Strole Agriculture  
(SP-15-00009)

RE: Strole Agriculture Short Plat, SP-15-00009

**STROLE AG SHORT PLAT
SP - XX-XX**
A PORTION OF THE W 1/2 OF SECTION 35, TOWNSHIP 19
NORTH, RANGE 18 EAST, W.M. KITTITAS COUNTY,
WASHINGTON

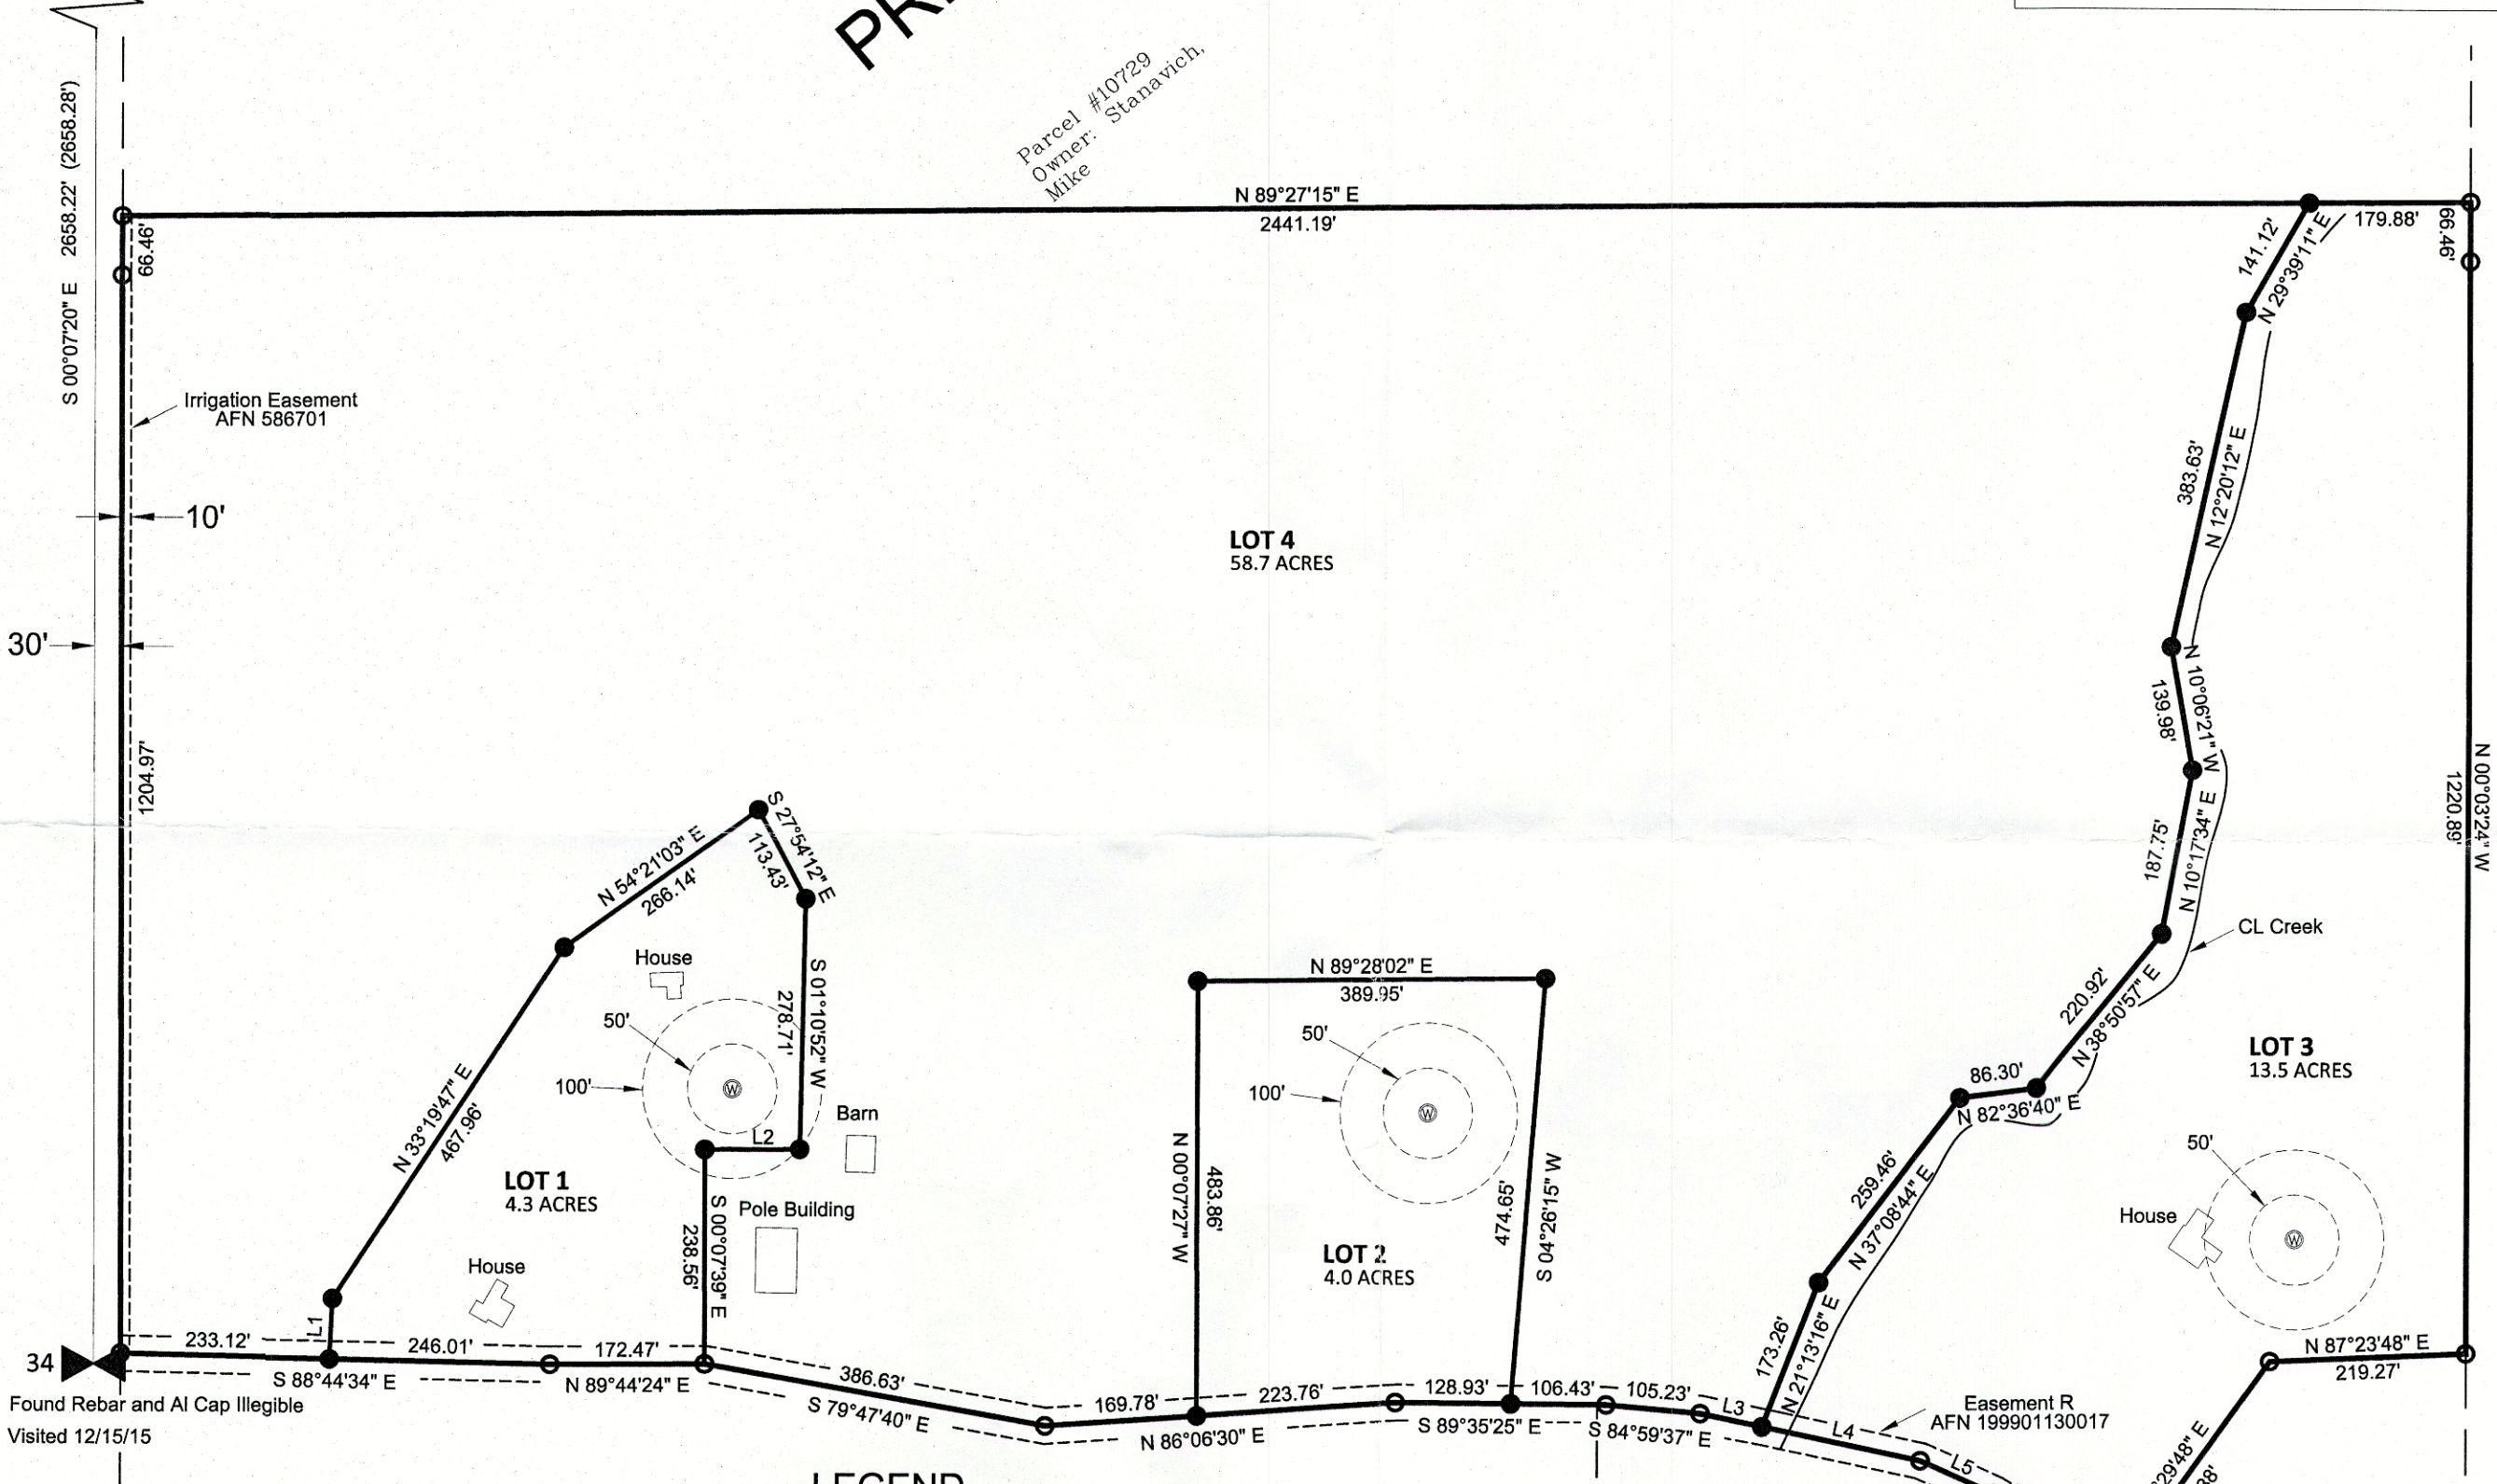
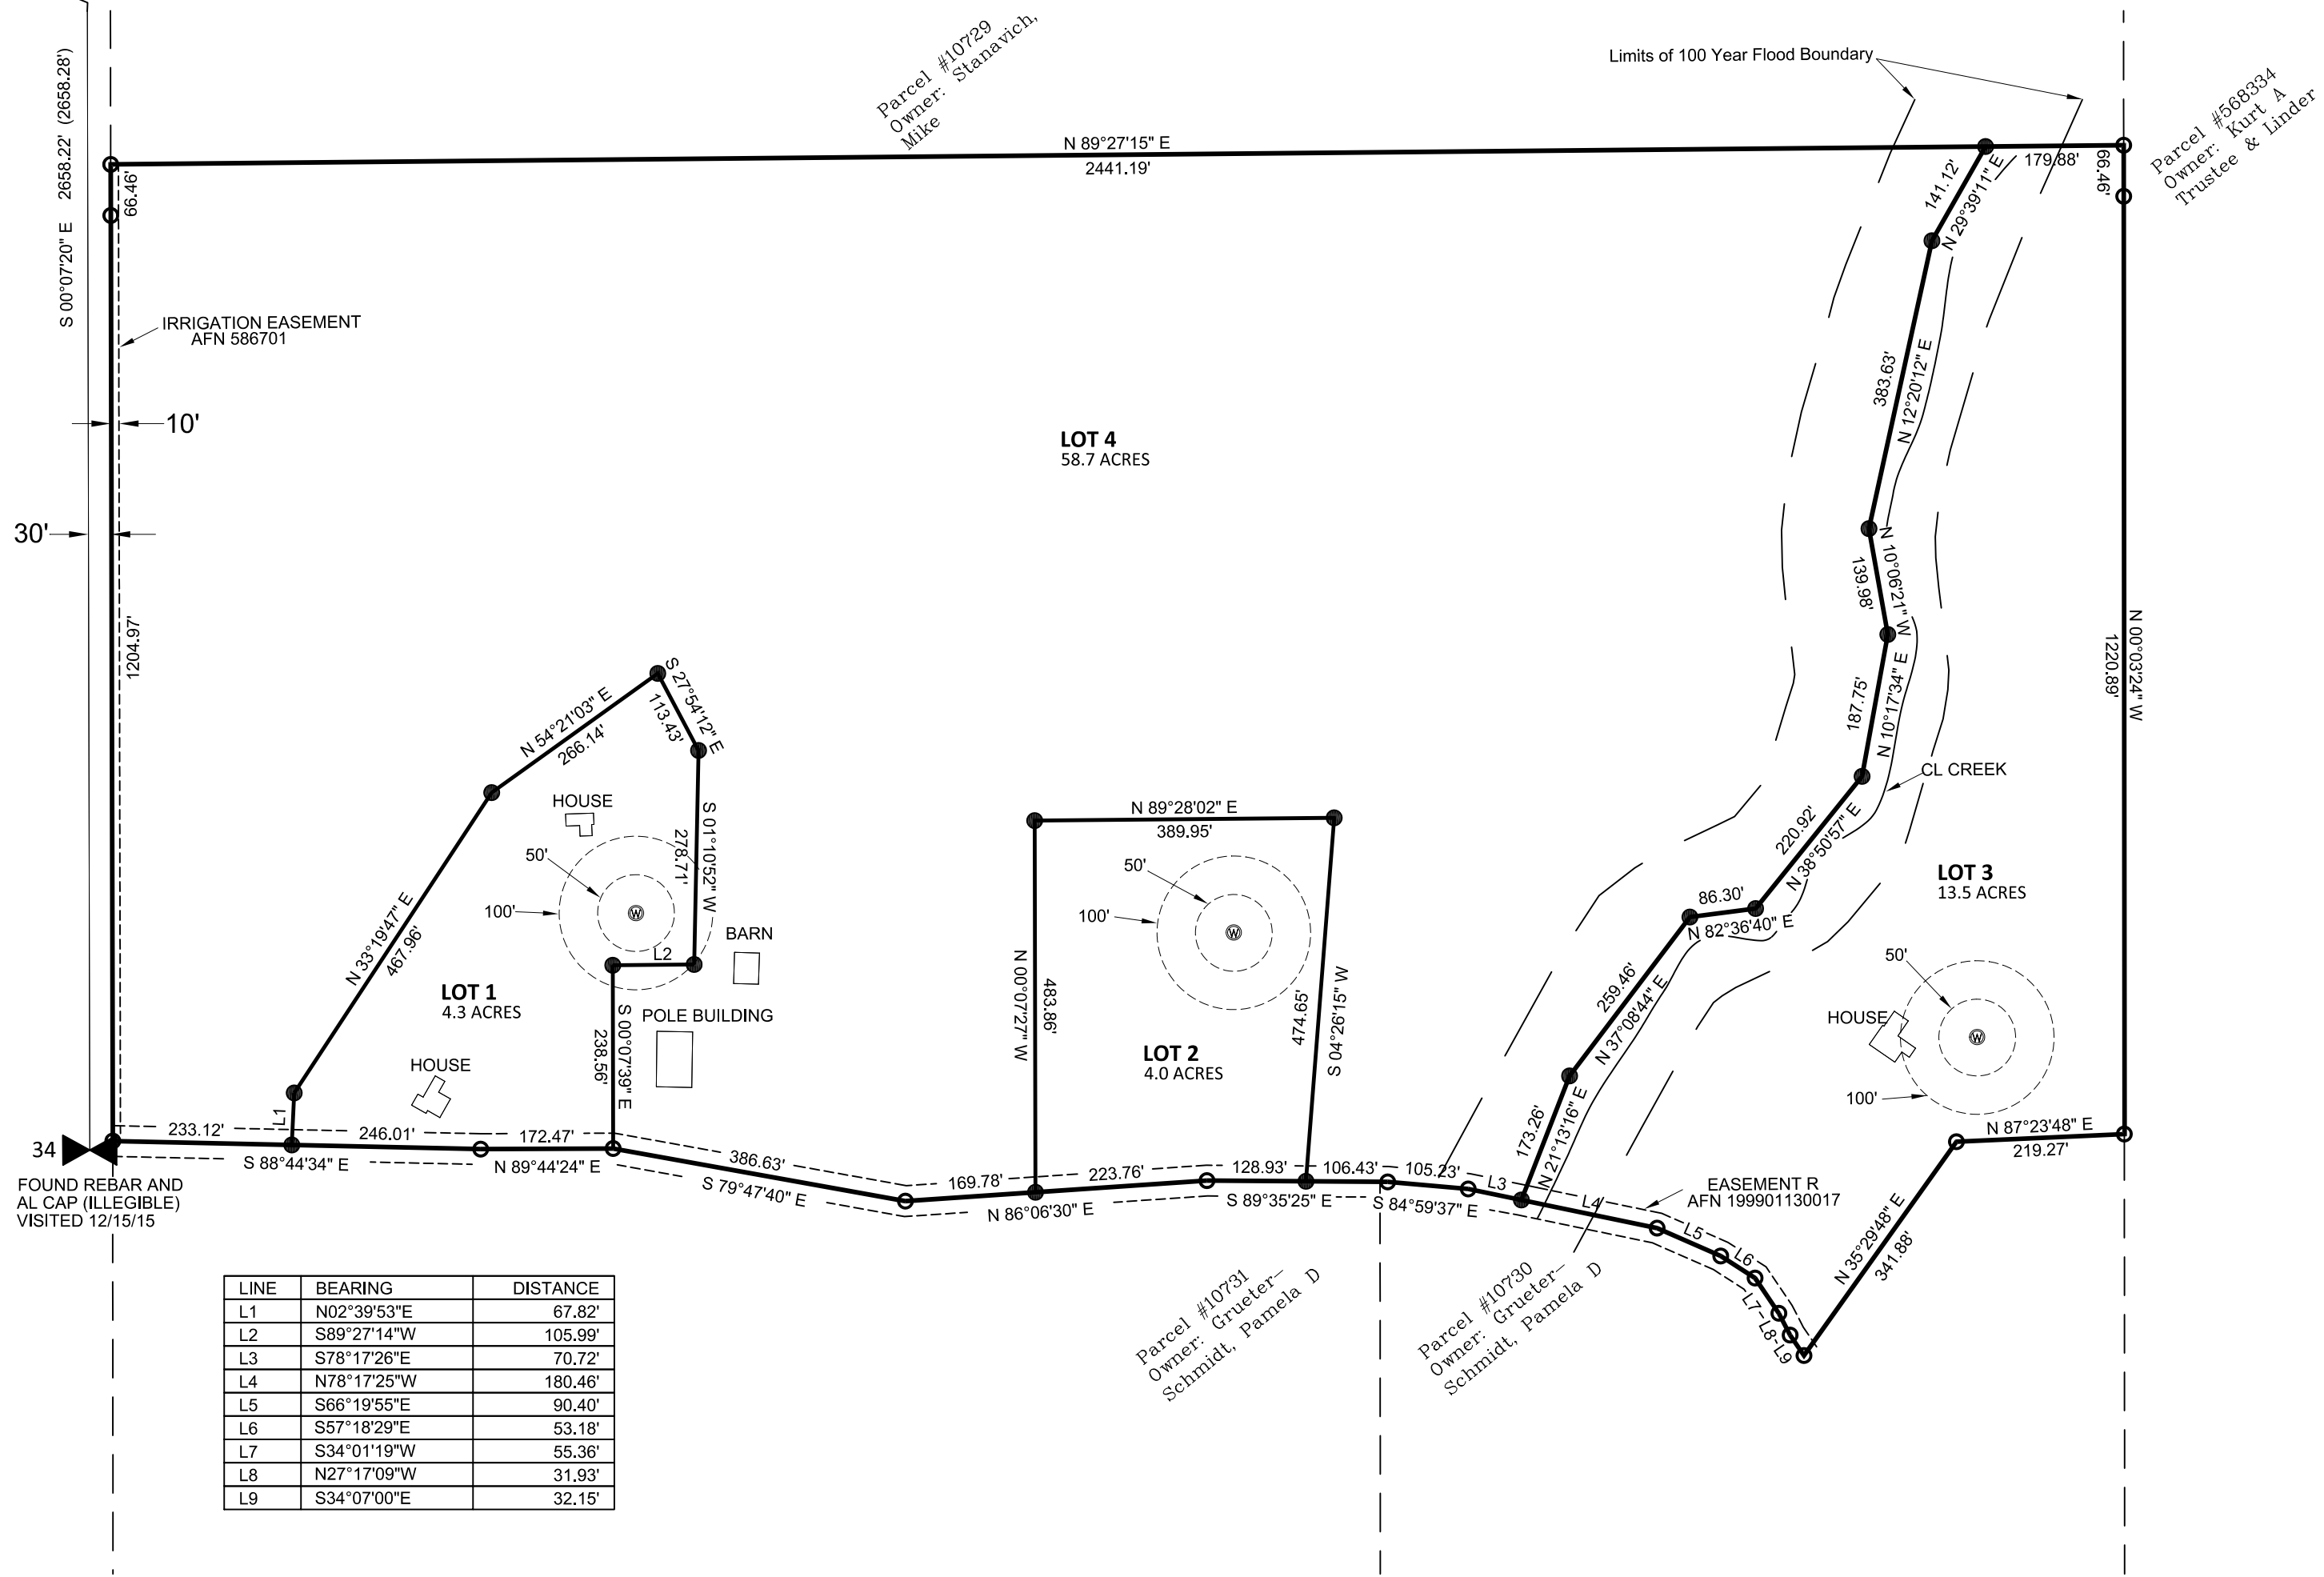
During review staff has determined that a revised site plan showing all septic's and drain fields is required in order to continue review. Additional information must be submitted to CDS within 180 days :
